Application No: BR/53/26/PL
Site Address: 57 Queensway Bognor Regis PO21 1QN
Description of works: Demolition of existing brick-built garages, removal of canopy structure, remediation of contaminated land and construction of 18 No. flats over 3 storeys (resubmission following BR/67/25/PL). This application is in CIL Zone 4 (Zero Rated) as flats.

NO OBJECTION

Roof Plan

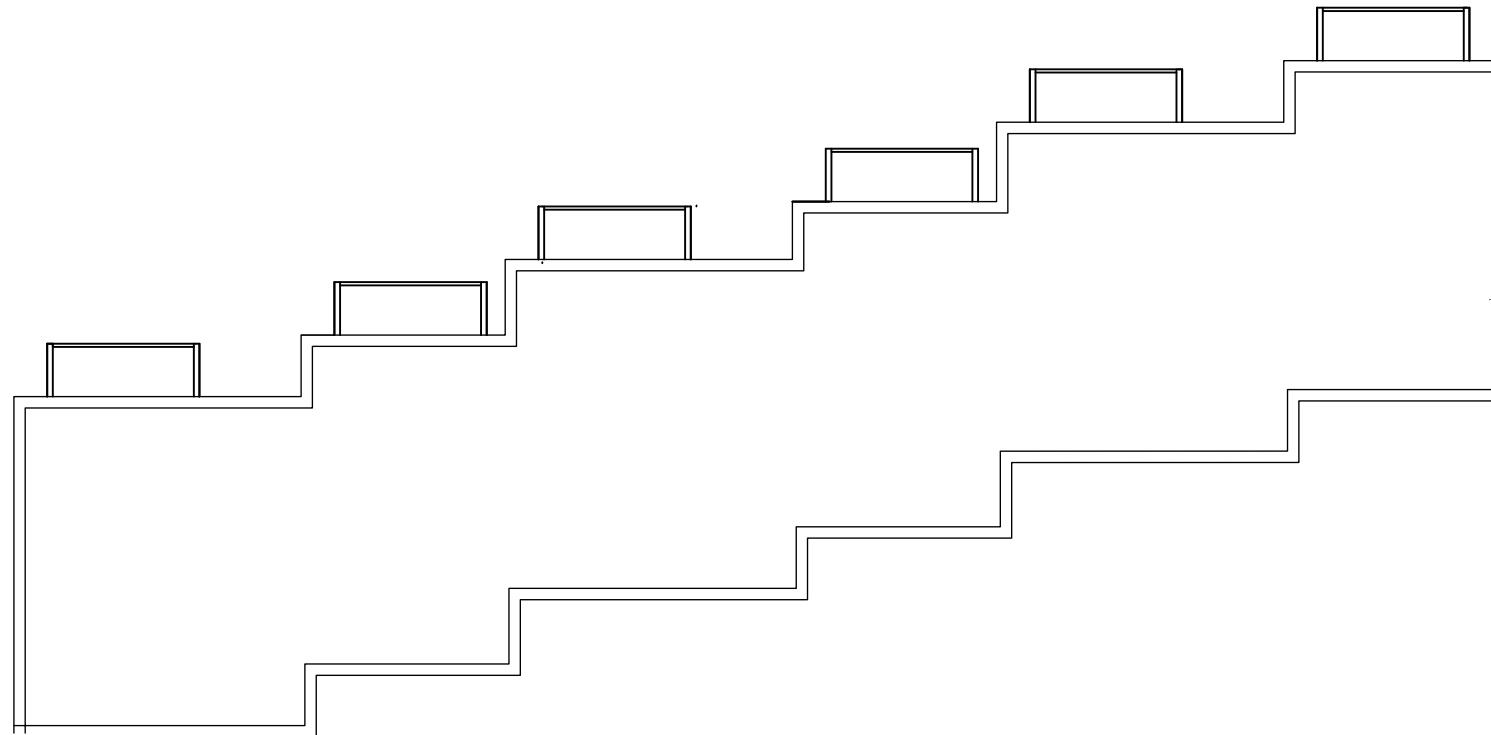
Members also wished to see a pitched roof incorporated into the design, as this would be more in keeping with the character and appearance of the surrounding area, with solar panels installed on the roof.
